1 SITE PLAN
SCALE: 1"=20'-0"

COUNTY FILE NO. PPR-17-056/ESQ-17-037

MASTER BLASTER
 GBP LOT 35-2
 1259 COLE VIEW
 COLORADO SPRINGS, CO 80915
 EL PASO COUNTY, COLORADO

1 SITE PLAN
SCALE: 1"=20'-0"

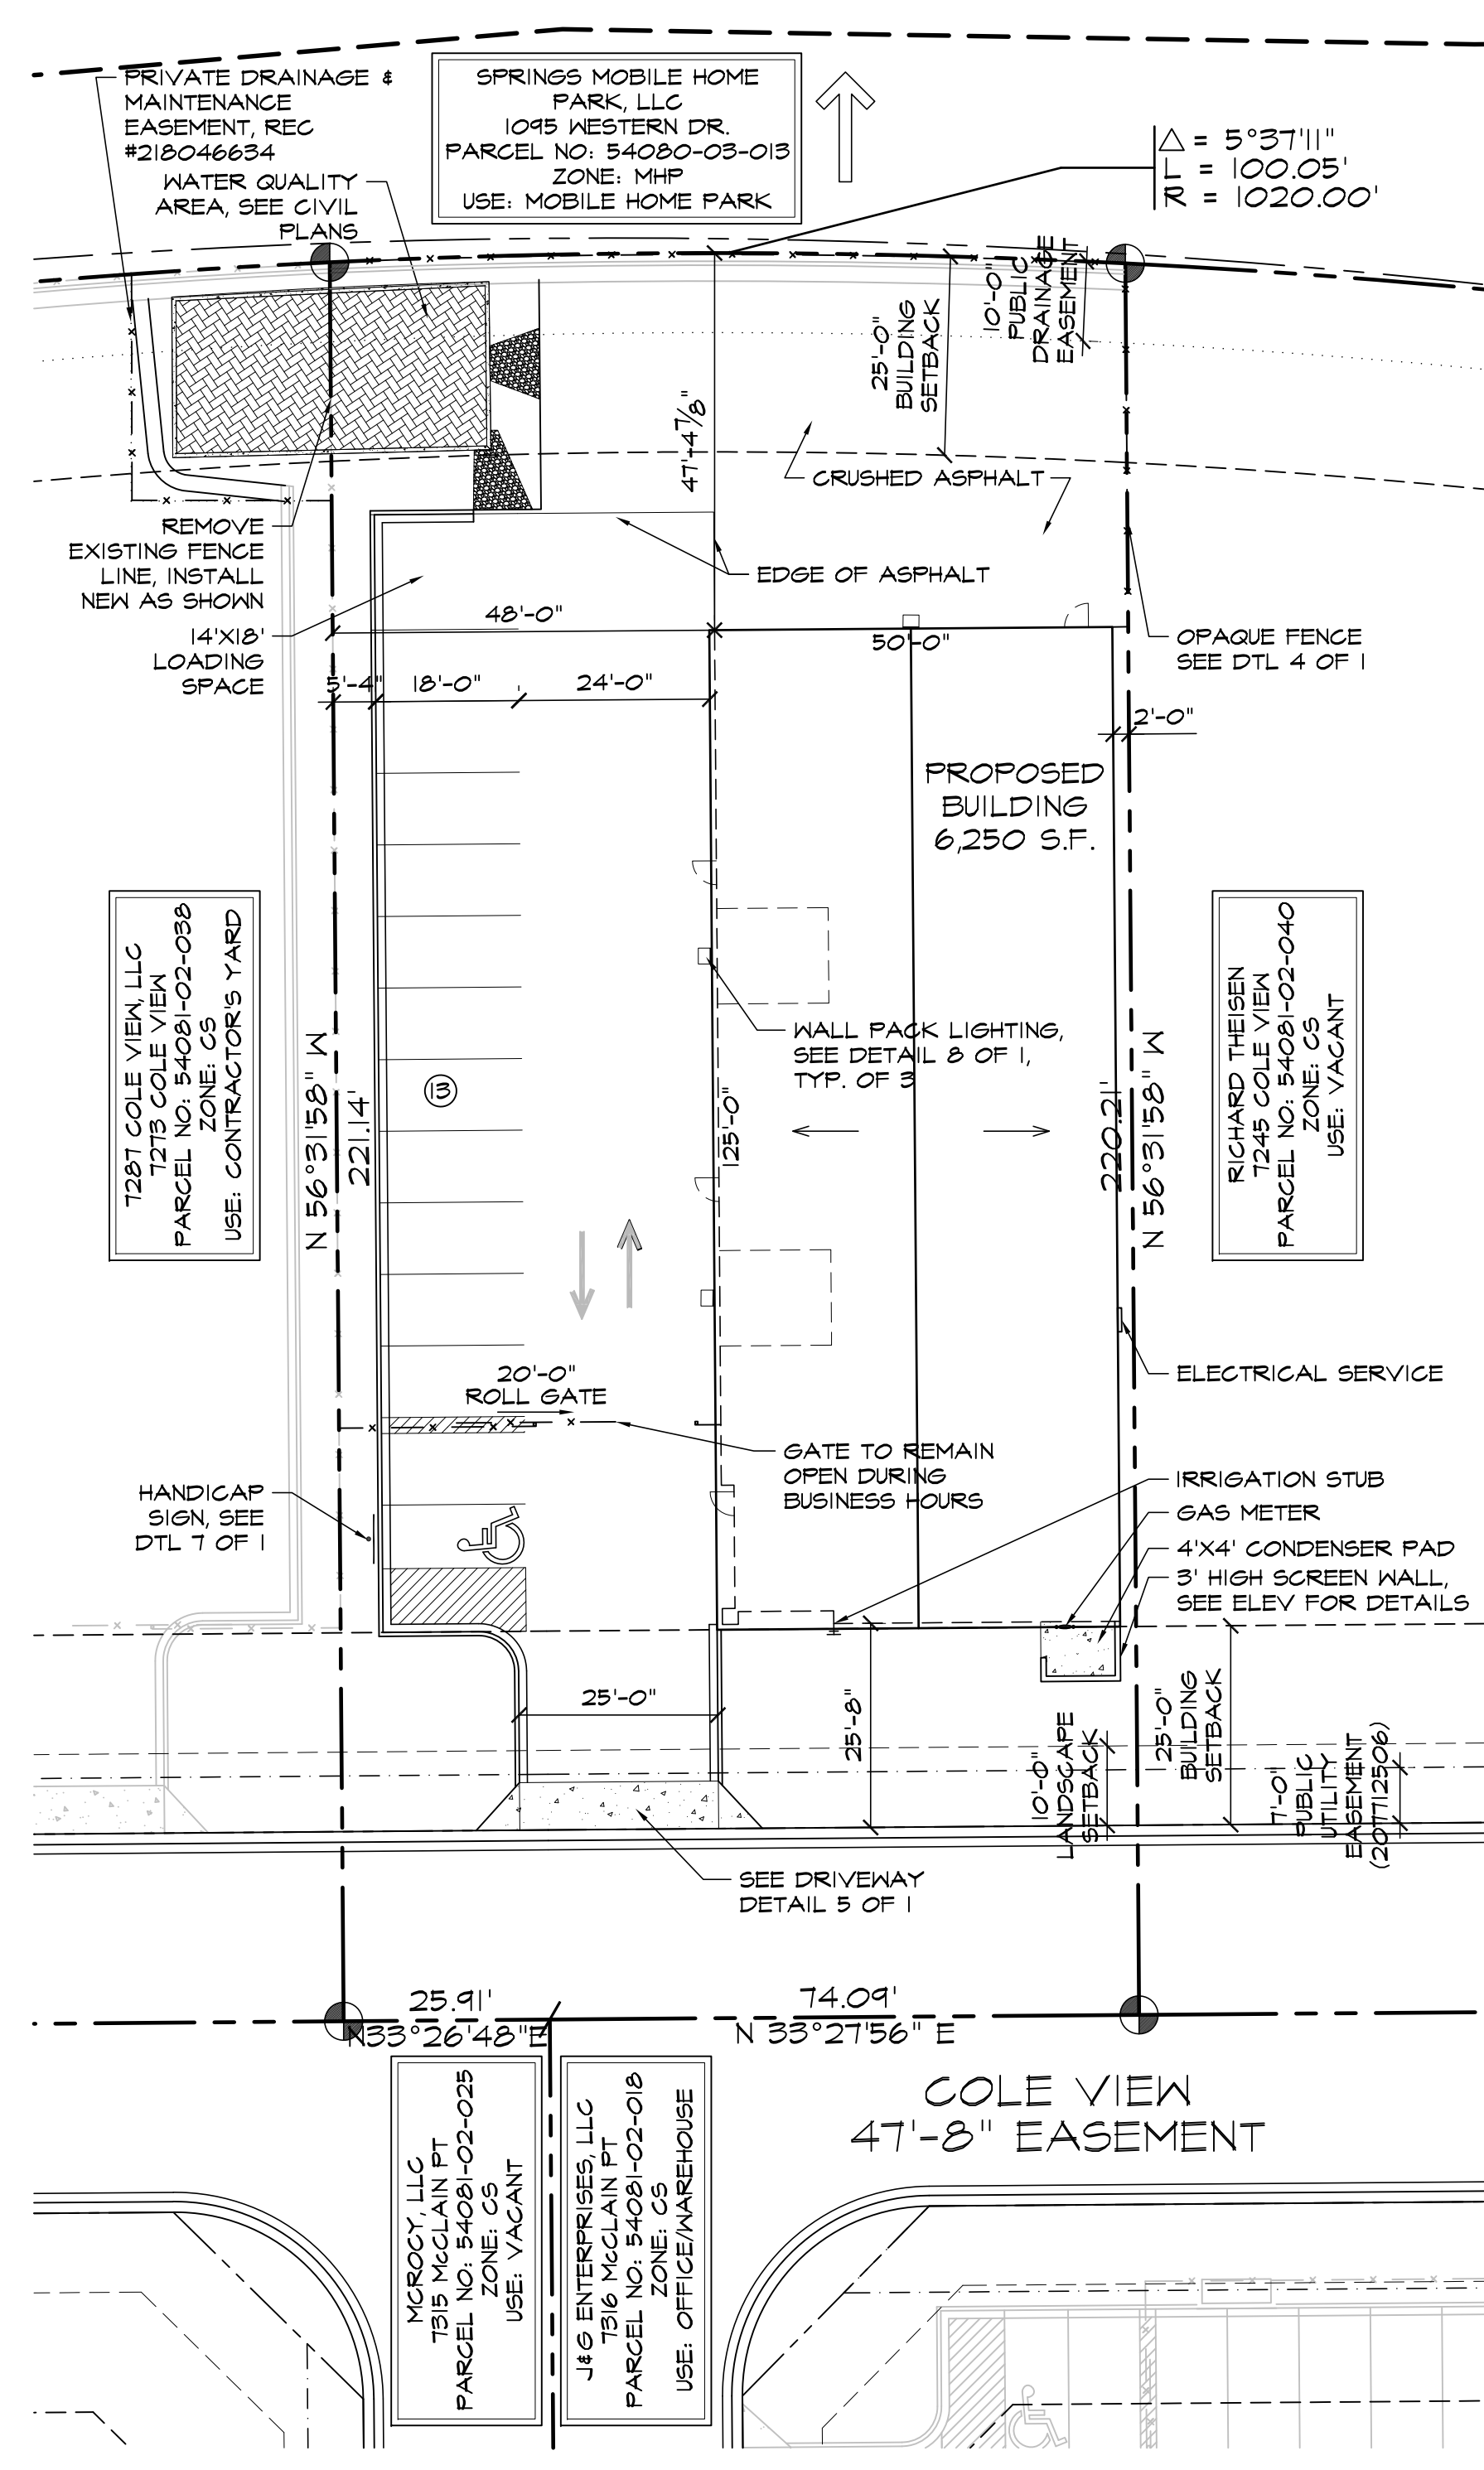
NOTE: REFER TO THE APPLICANT MUST OBTAIN A PERMANENT DRAINAGE EASEMENT FROM LOT 34. THE COUNTY WILL REQUIRE A COPY OF THE RECORDED DOCUMENT. THE AGREEMENT BETWEEN LOTS MUST OUTLINE THE MAINTENANCE RESPONSIBILITY FOR THE PERMANENT FACILITY.
 Show the easement (w/ bearing & distance label) on the site plan with reference to the reception number of the recorded easement agreement.
 Review 3: Unresolved.
